**Application by Highways England for the A1 in Northumberland: Morpeth to Ellingham  
The Examining Authority's written questions and requests for information (ExQ2)  
Issued on 19 March 2021.**

**Responses are due by Deadline 5: 1 April 2021.**

0 10 100

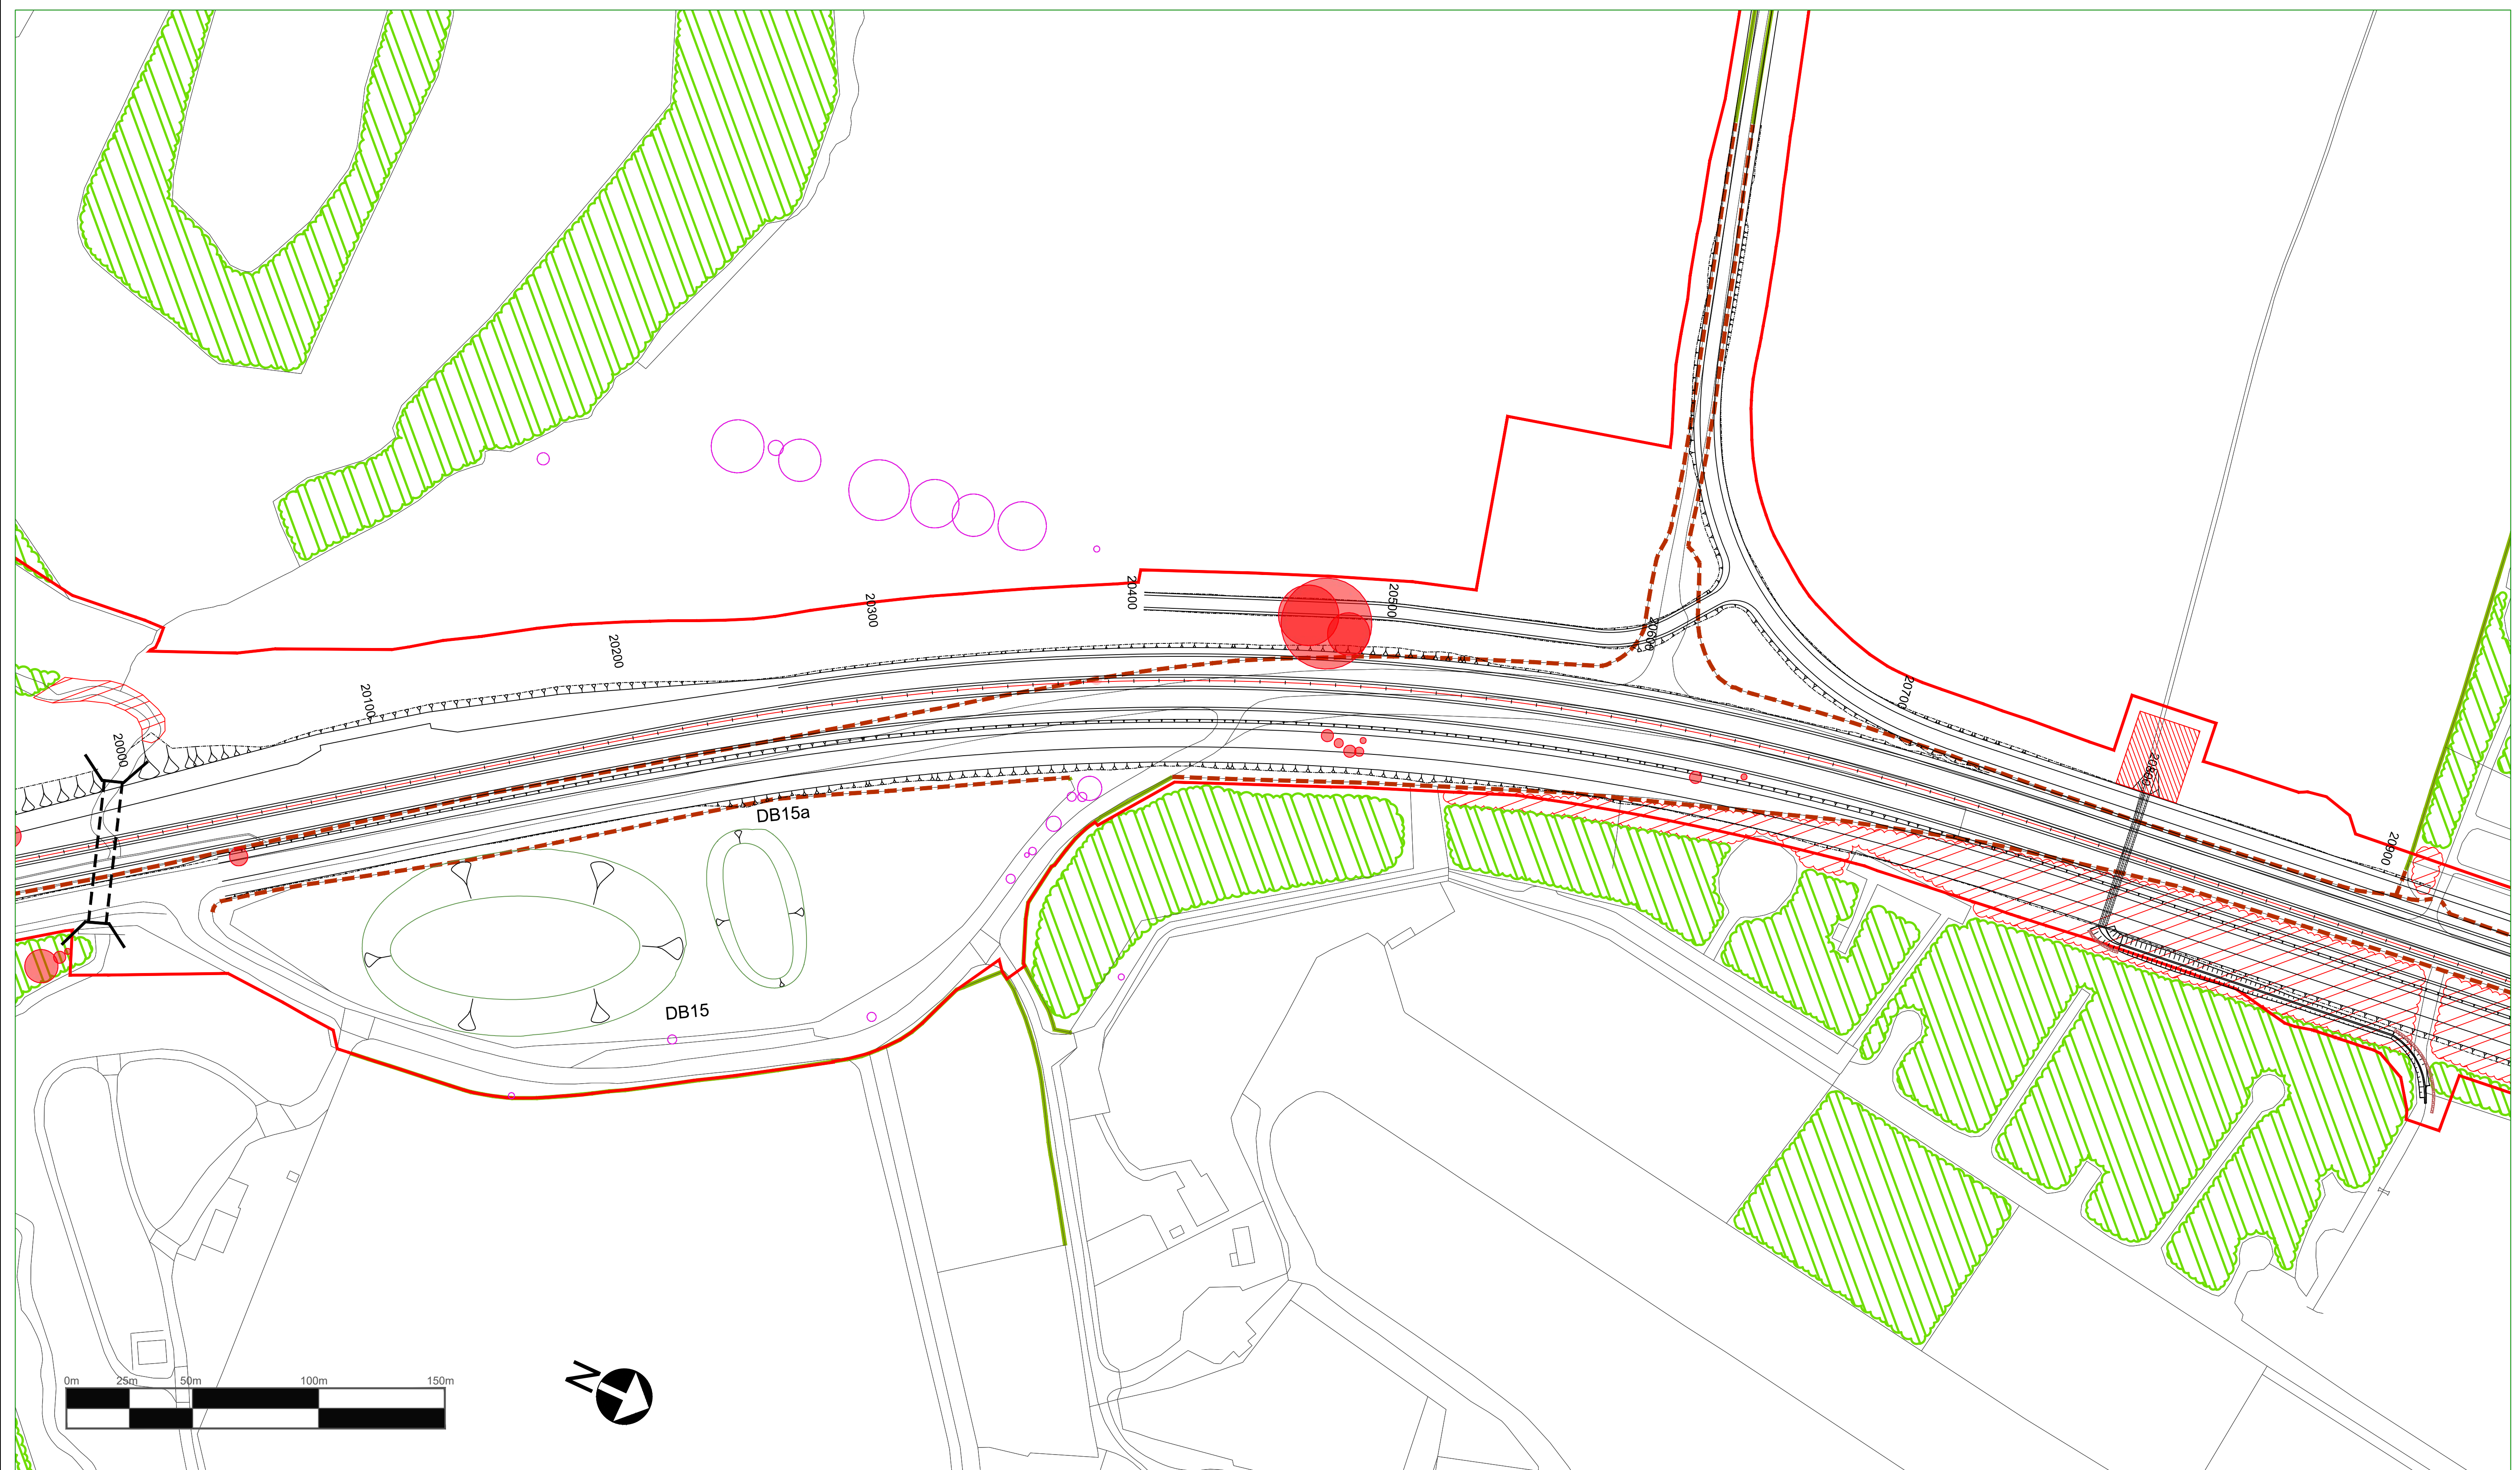
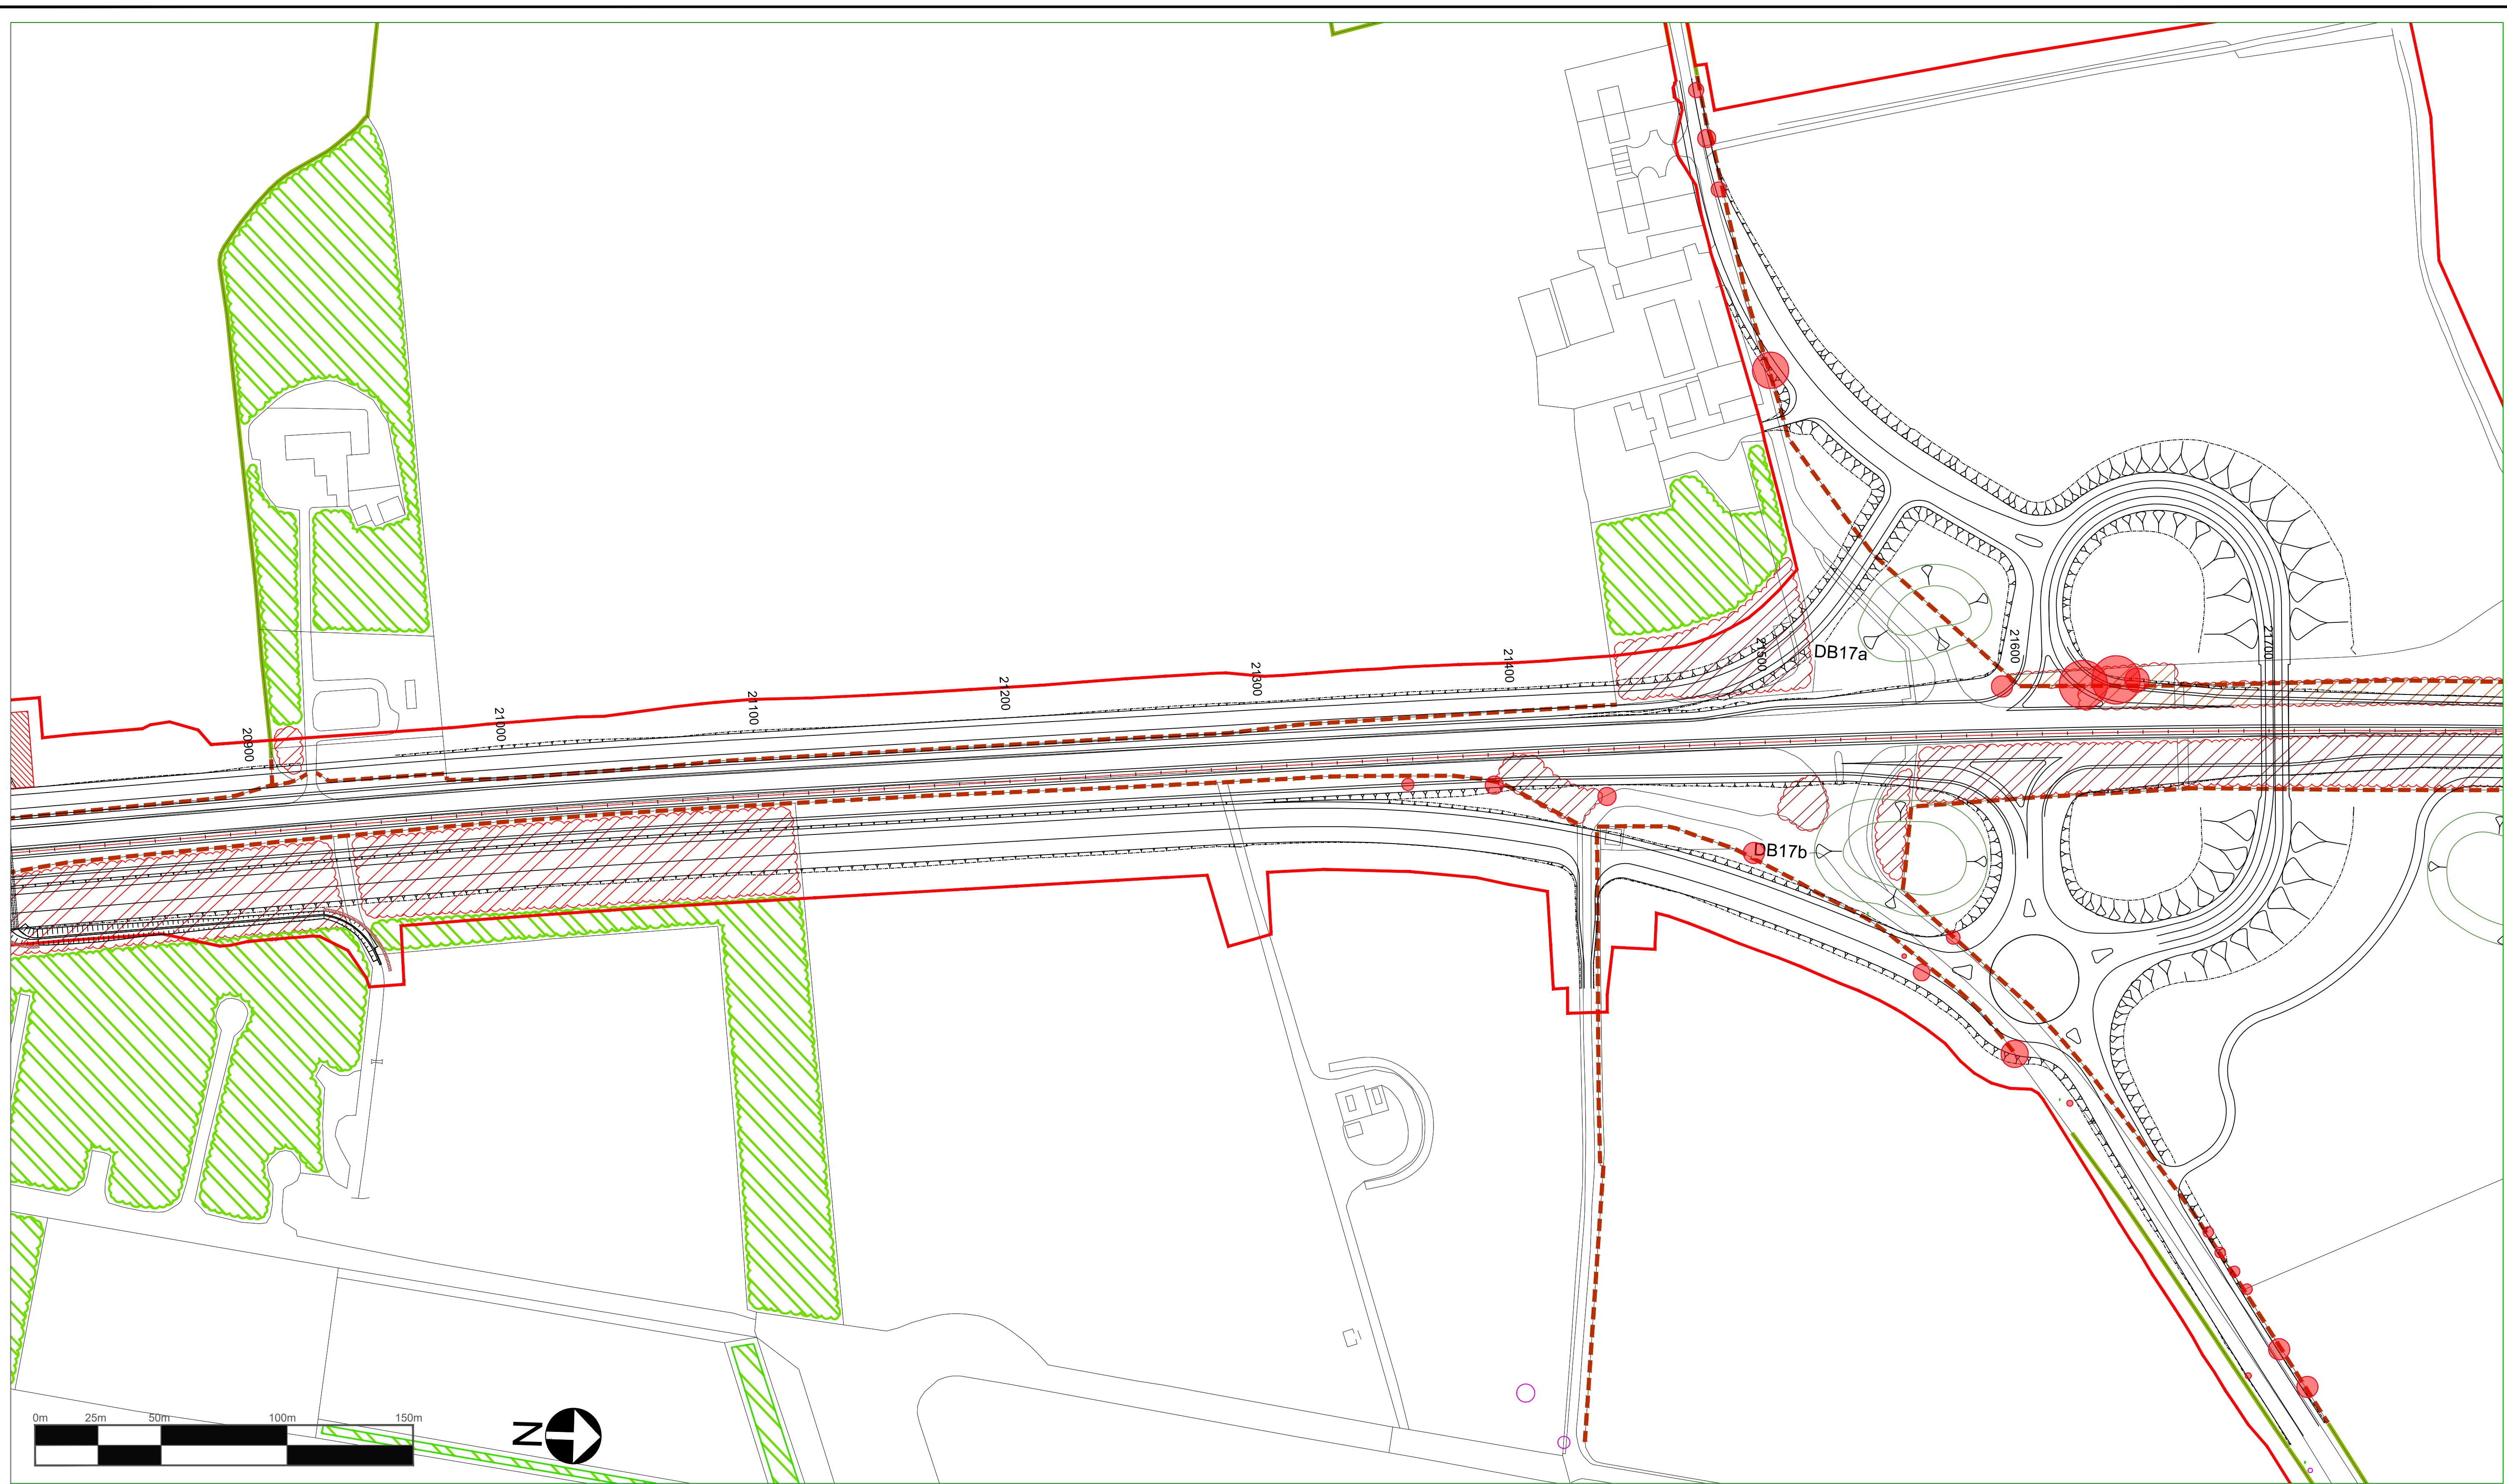
<b>ExQ1</b>	<b>Question to:</b>	<b>Question:</b>
		<b>PART B</b>
LV.2.21	Applicant	Vegetation Clearance Plans [REP4-003] show the existing vegetation to be retained, the existing vegetation to be removed and also the results of the Arboricultural Survey. Can the Applicant confirm the intentions for vegetation removal in front of West Linkhall Farm and West Lodge at Charlton Hall? How would this be secured through the DCO?
<b>MATERIAL RESOURCES</b>		
MR.2.1	Applicant	The Applicant's Comments on the LIR [REP3-025] responding to paragraph 6.10.2 of the LIR indicate that all practicable efforts will be made to achieve sustainable resource management and that information on achievements in this context will, where appropriate, be made available to NCC during detailed design. What is the mechanism by which this information will be provided?
MR.2.2	NCC	The Applicant's Comments on the LIR [REP3-025] responding to paragraph 6.10.3 of the LIR address discrepancies raised by NCC in the potential capacity for inert landfill in the county as set out in Table 13-11 of the ES [APP-056] [APP-057]. Is NCC content with the Applicant's response?
